Appeal Decision

Appeal Ref: APP/C3105/W/23/3321715

The Pheasant Pluckers Inn, Street Through Burdrop, Burdrop OX15 5RQ

FLOOR PLAN

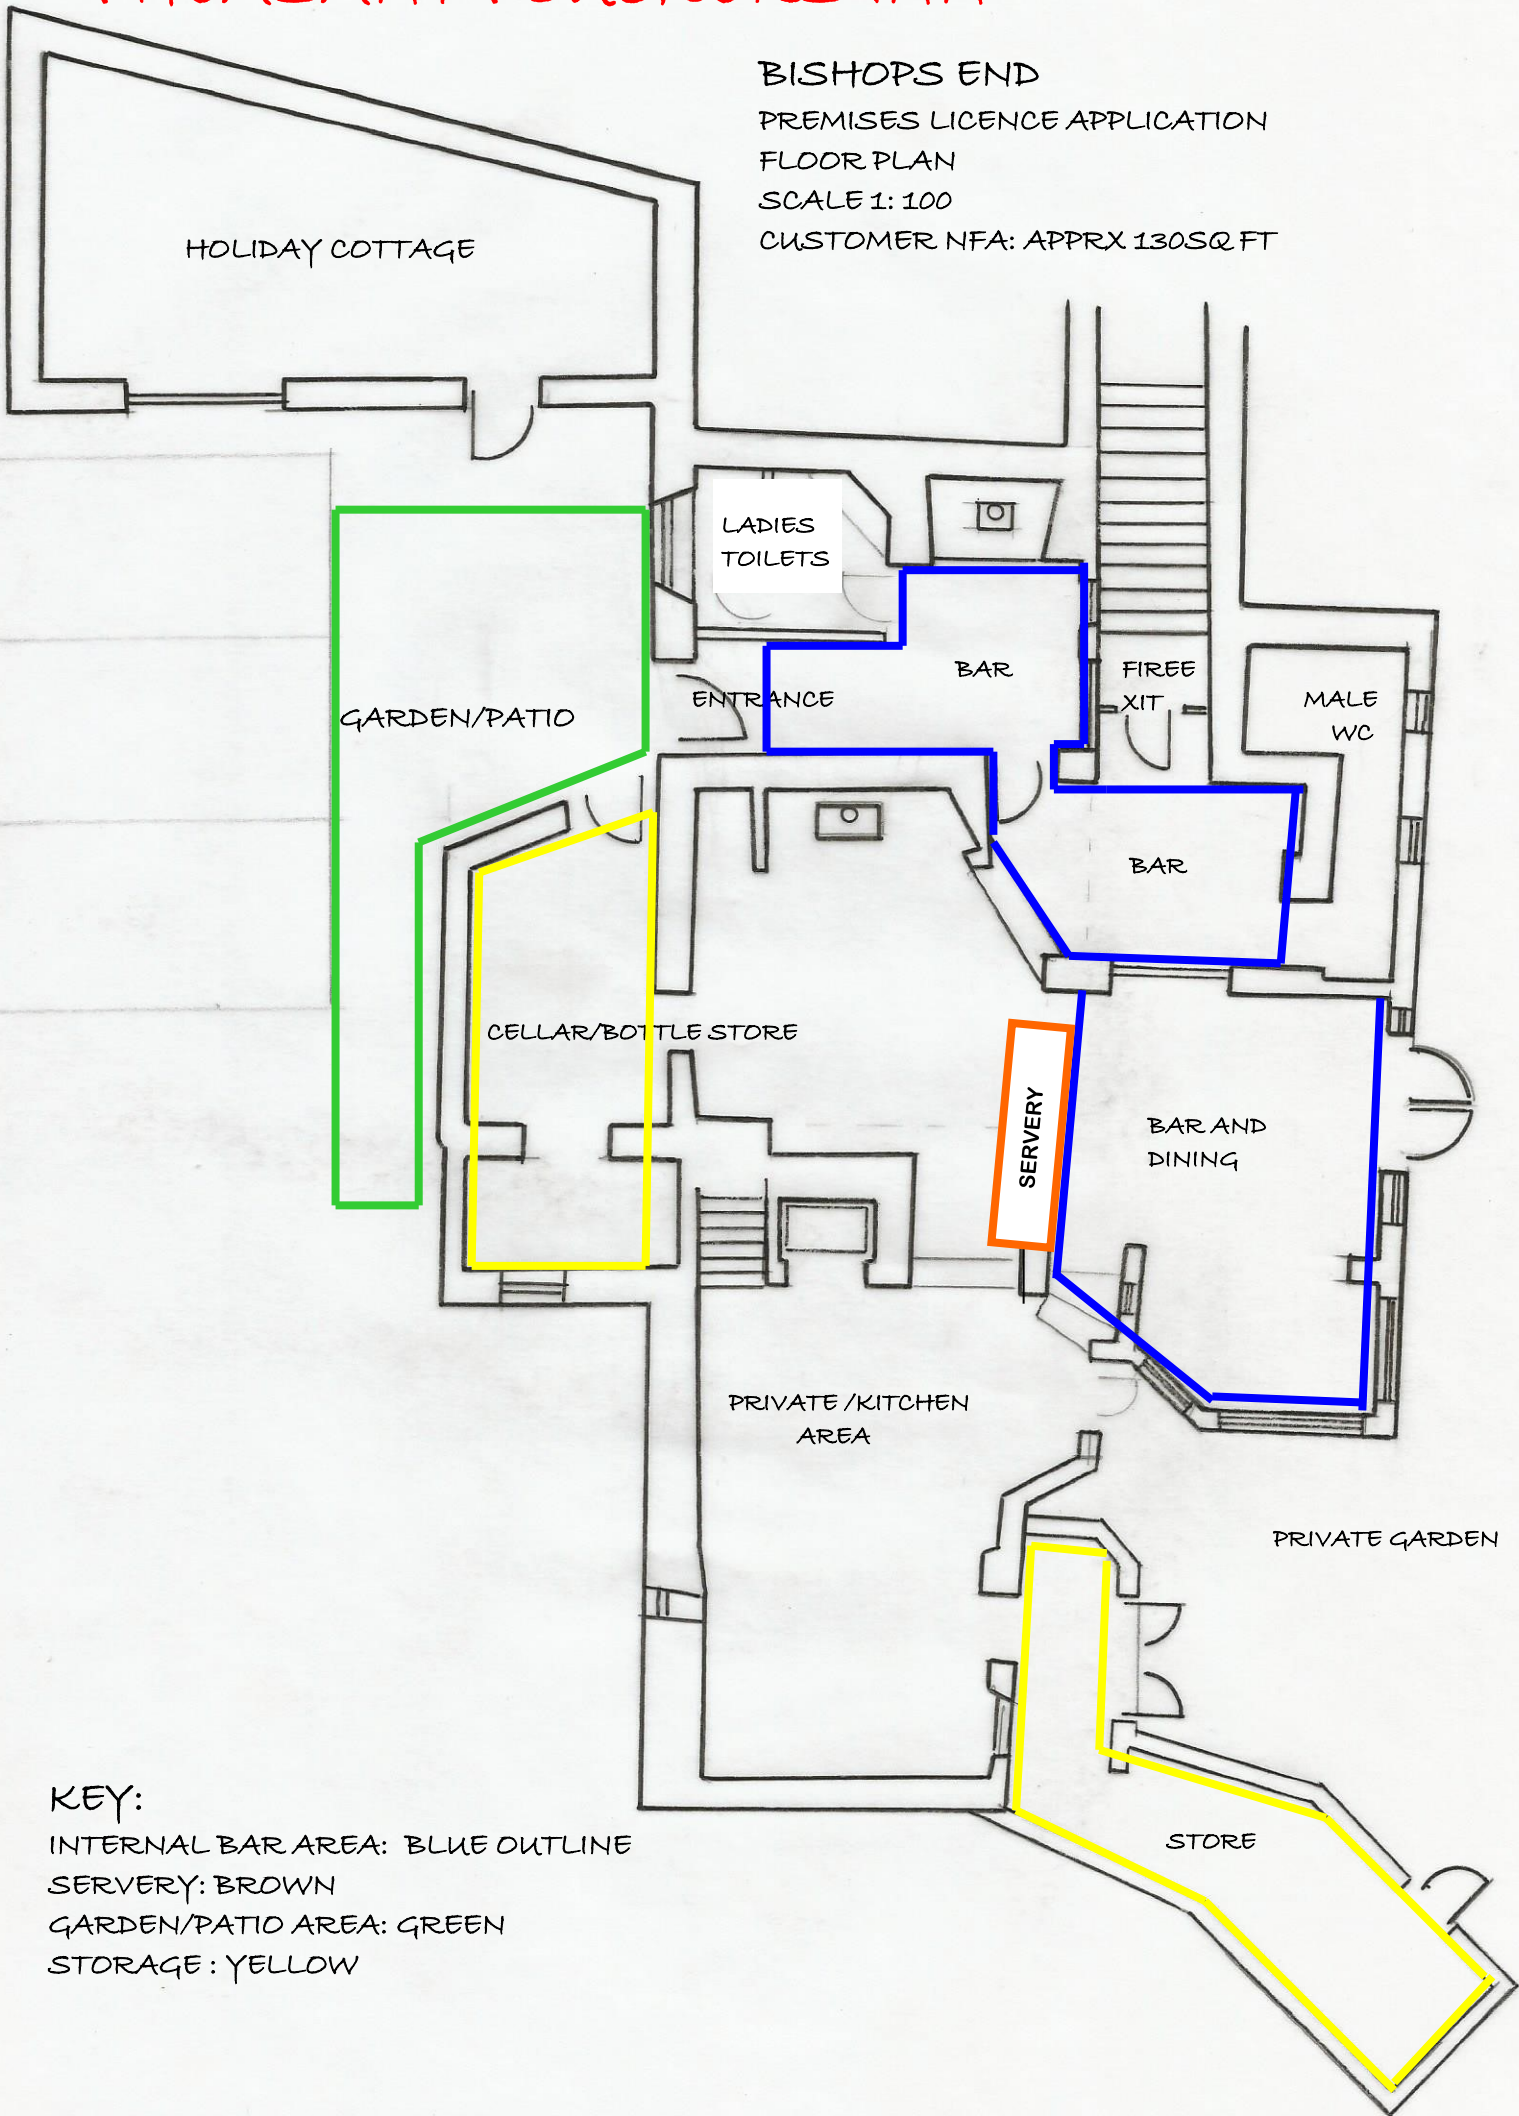
9. In interpreting the requirements of the DMPO2015, the minimum information required to make a determination as to this particular application would be the application form with signed certificate, location plan, detailed planning statement addressing the above mentioned factors, a viability statement and a detailed floor plan of each floor of the buildings seeking to change the use of and showing the configuration of the proposed use as this could determine size of rooms and position of windows, amongst other considerations. An elevation plan, whilst desirable, would in my mind not be absolutely necessary to describe the change of use development which is the subject of the application. I note that a Floor Plan has been submitted with the appeal, however much of the floor plan is blank, only shows the ground floor, and does not make reference to the proposed C1 use and is therefore inadequate.
